Environmental Health Division
1675 W. Garden of the Gods Road
Suite 2044
Colorado Springs, CO 80907
(719) 578-3199 *phone*
(719) 578-3188 *fax*
www.elpasocountyhealth.org

11660 Green Acres, ADR-19-013

1 SITE PLAN  
SCALE: 1" = 40'

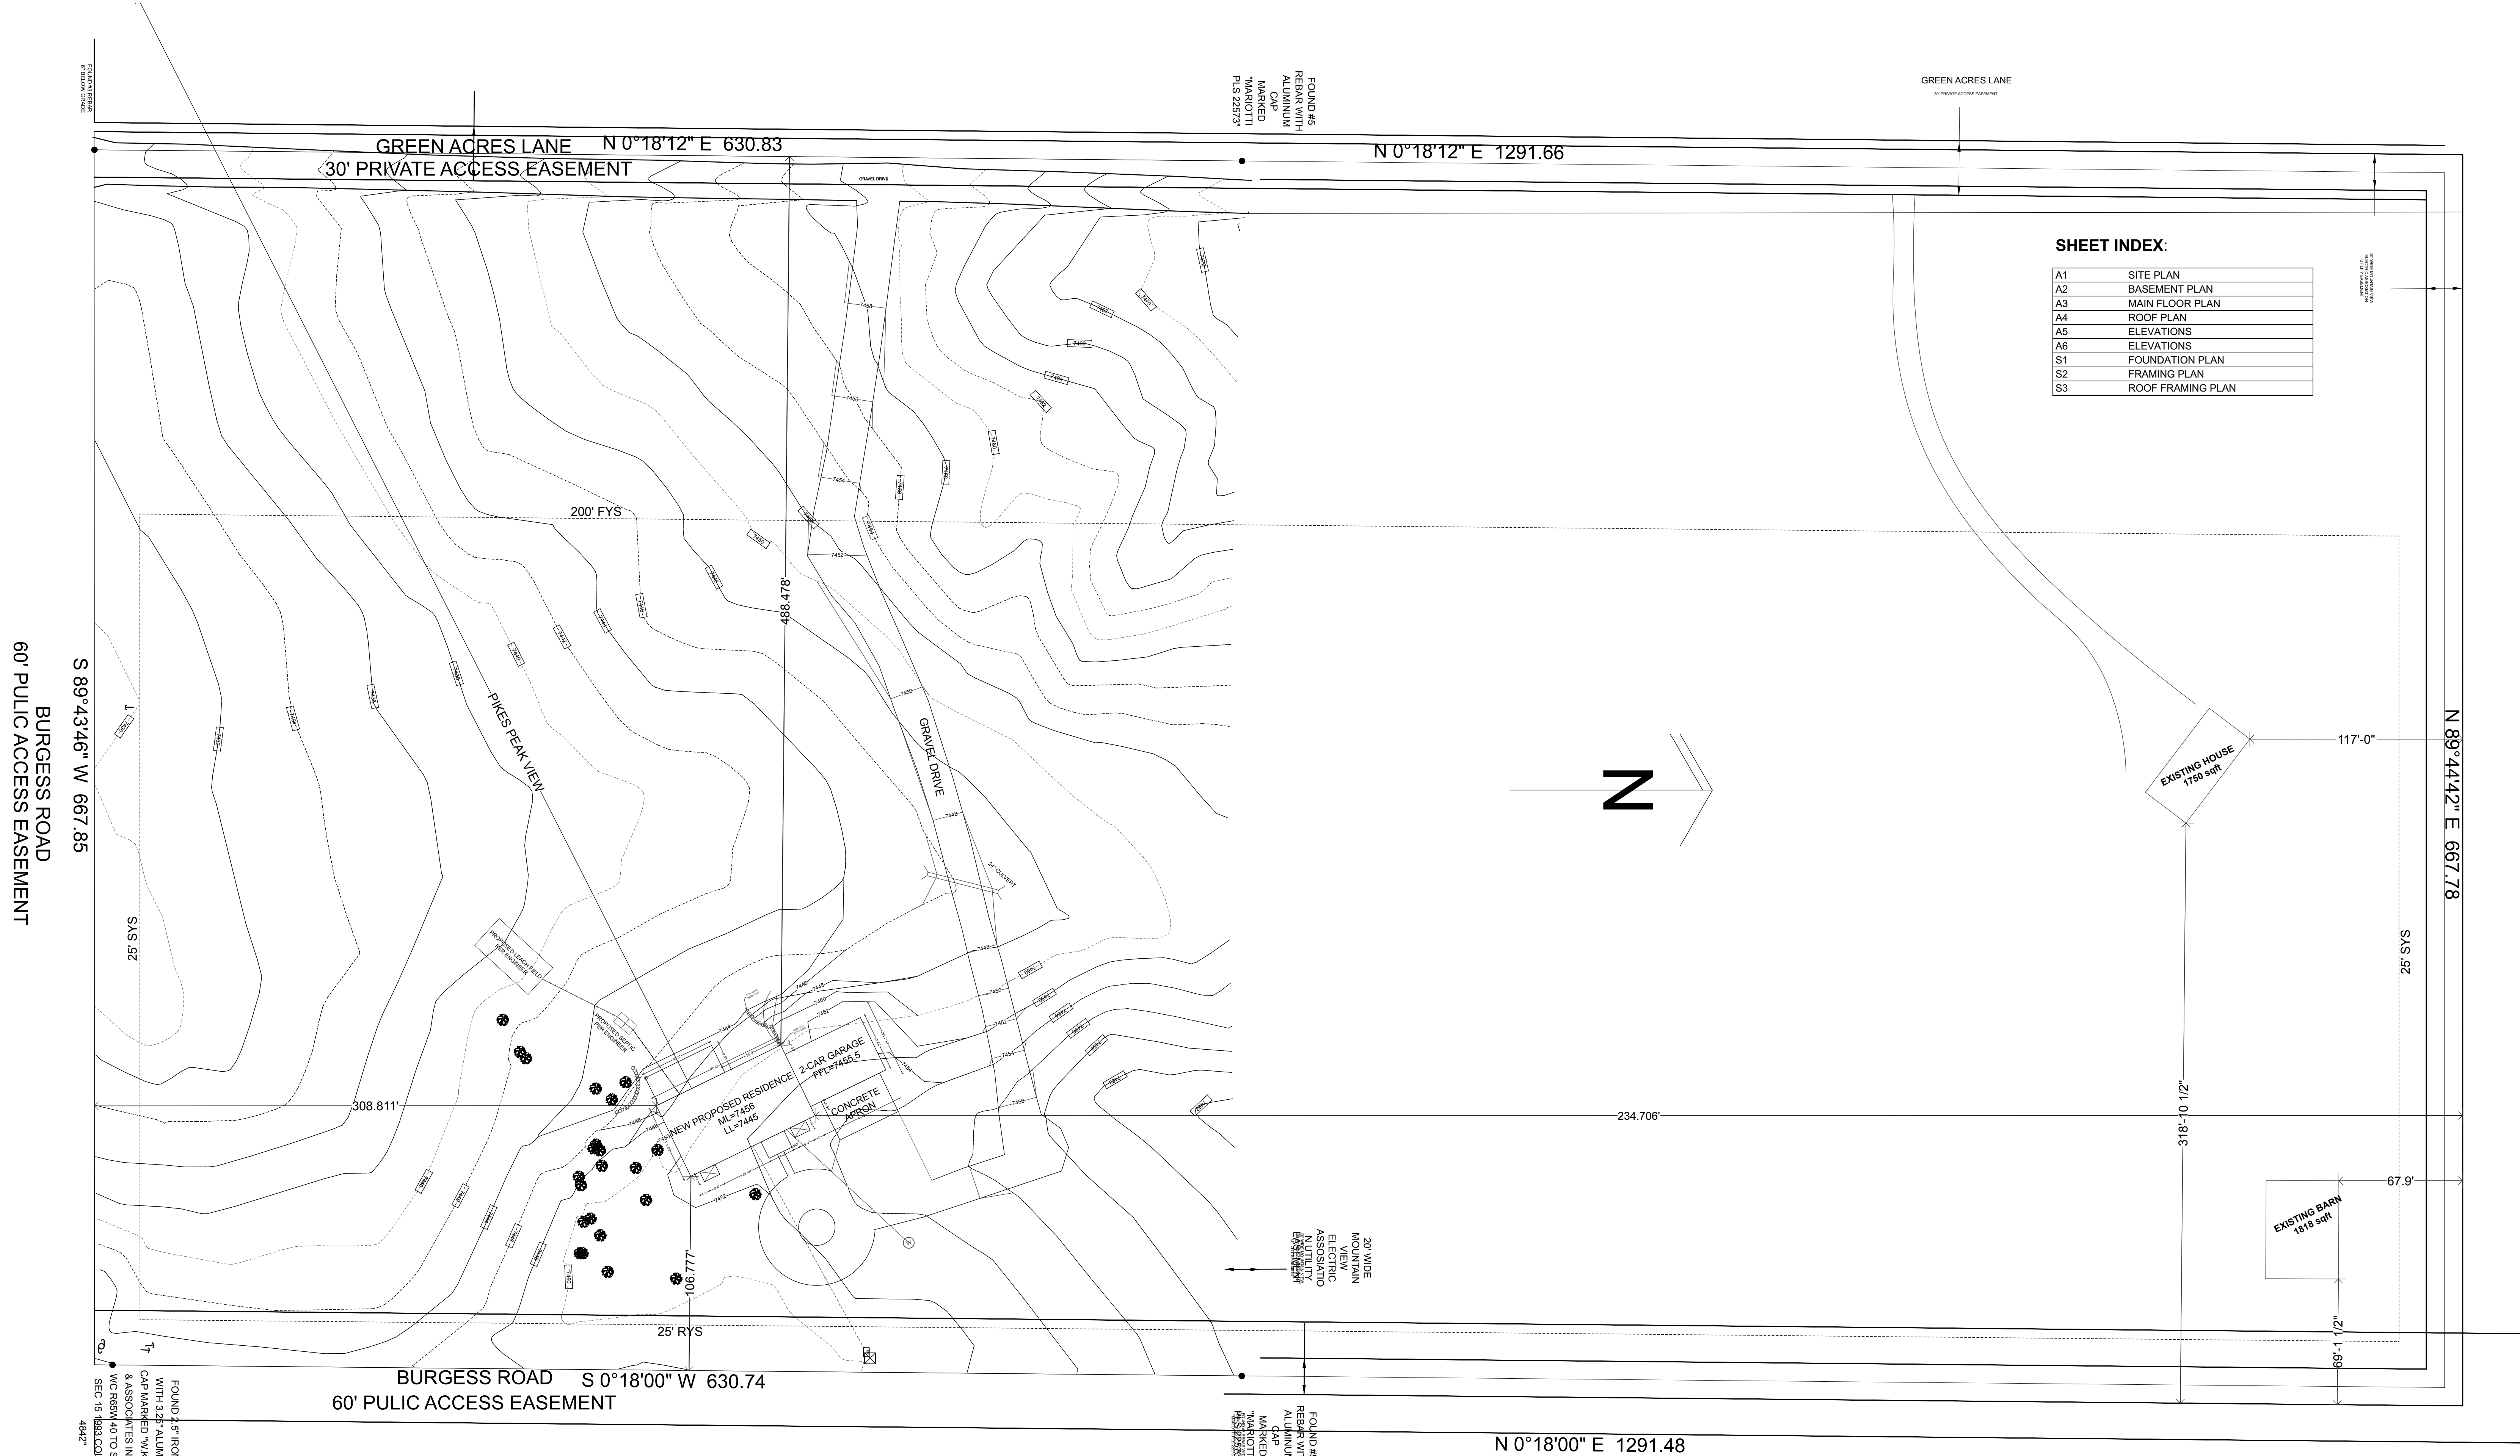
- **No public health issues noted with this request; however, the new house requires full compliance with the El Paso County Onsite Wastewater Treatment System (OWTS) Regulations. Advise all contractors not to drive or park on the proposed location of the new soil treatment area. Recommend fencing the area off as a protective measure.**
